## **Development Facilitation Team (DFT) – Review Comments**

**Project No: PR-2023-009637      Date: 10/30/2024      Agenda Item: #5 & 6      Zone Atlas Page: F-11**

**Request: 5. - Lot line adjustment    6. – Sidewalk and landscape buffer waiver to allow existing conditions to remain (final Plat is associated and pending this request)**

**Location: 5909 WESTWARD LANE NW & 4815 NORTHERN TRAIL NW**

**PLAT OF
LOT 1A, RAY PENA SUBDIVISION &
LOT 14A, QUAKER HEIGHTS SUBDIVISION**

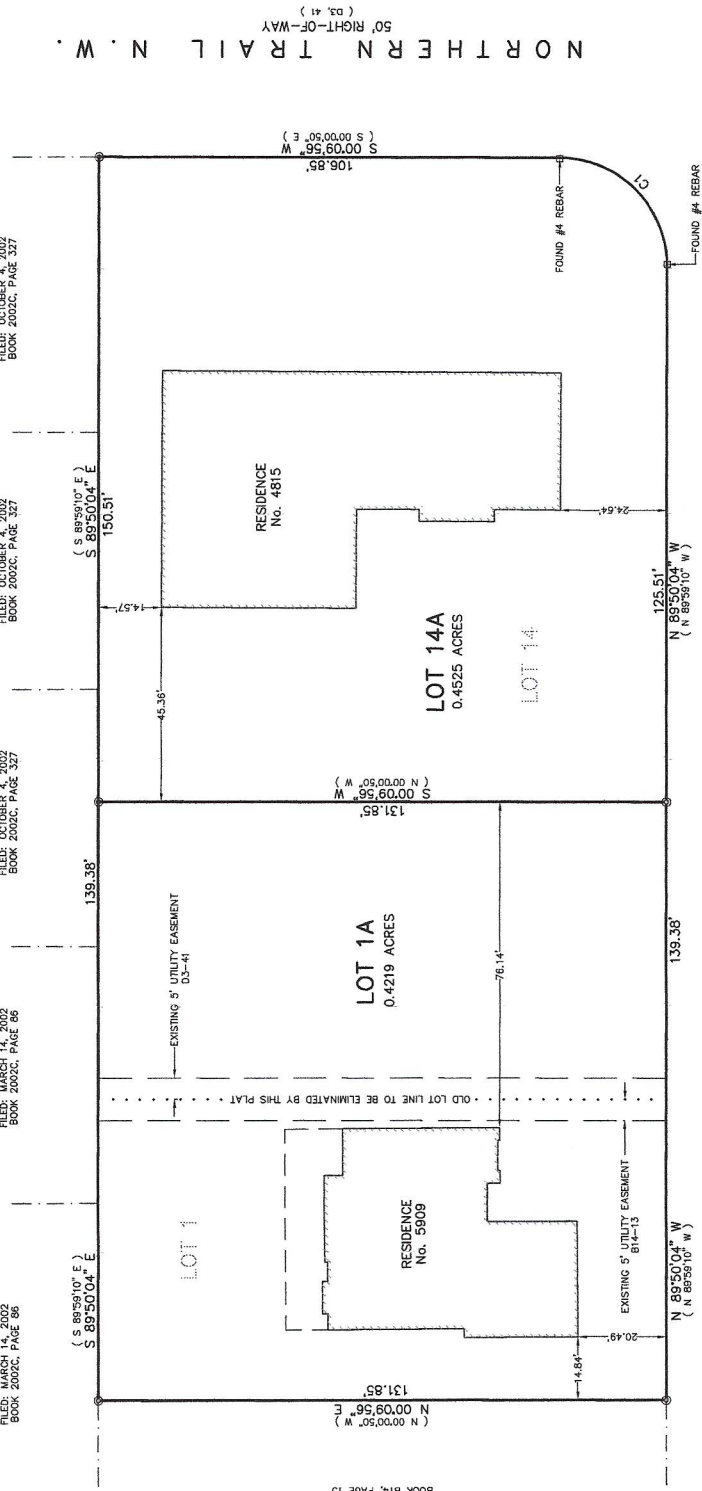
1. Property is zoned R-A, and must meet Dimensional Standards of IDO 5-1(C), Table 5-1-1, including minimum lot size of 10,890 ft (0.25 acre), minimum lot width of 75 ft, and setbacks of 20 ft Front; 10 ft, Side, and 25 ft, Rear.
2. Property is located within an Area of Consistency, as well, and must meet Contextual Lot Size standards, as per IDO 5-1(C)(2) for construction of new residential development.
3. Proposed lot sizes fall within the allowable contextual lot sizes for this area. Allowable lot size range:
  - Minimum lot size 75% = .3025 acre
  - Maximum lot size 125% = .5041 acre.

*Note: Contextual lot size calculations were based on the lots fronting on Westward Lane, the same street as the proposed lot for new development: Total = 2.8228 acres/7 lots = 0.4033 Average lot size.*

1. Property is zoned R-A, and must meet Dimensional Standards of IDO 5-1(C), Table 5-1-1, including minimum lot size of 10,890 ft (0.25 acre), minimum lot width of 75 ft, and setbacks of 20 ft Front; 10 ft, Side, and 25 ft, Rear.

2. Property is located within an Area of Consistency, as well, and must meet Contextual Lot Size standards, as per IDO 5-1(C)(2) for construction of new residential development.

3. Contextual lot size calculations will be based on the street fronting the same street as the proposed lot for new development, on Westward Ln.
  - 5909 = 0.210

- 5915 = 0.212
  - 5919 = 0.213
  - 5925 = 0.4278
  - 5900 = 0.26
  - 5904 = 0.26
  - 4732 = 1.24
  - Total = 2.8228/7 = 0.4033. Allowable lot size range: Minimum 75% = .3025; Maximum 125% = .5041.

4. As per these calculations, the proposed smaller lot size would need to obtain a Variance to Contextual lot size required prior to re-plat.
5. No further comments at this time.
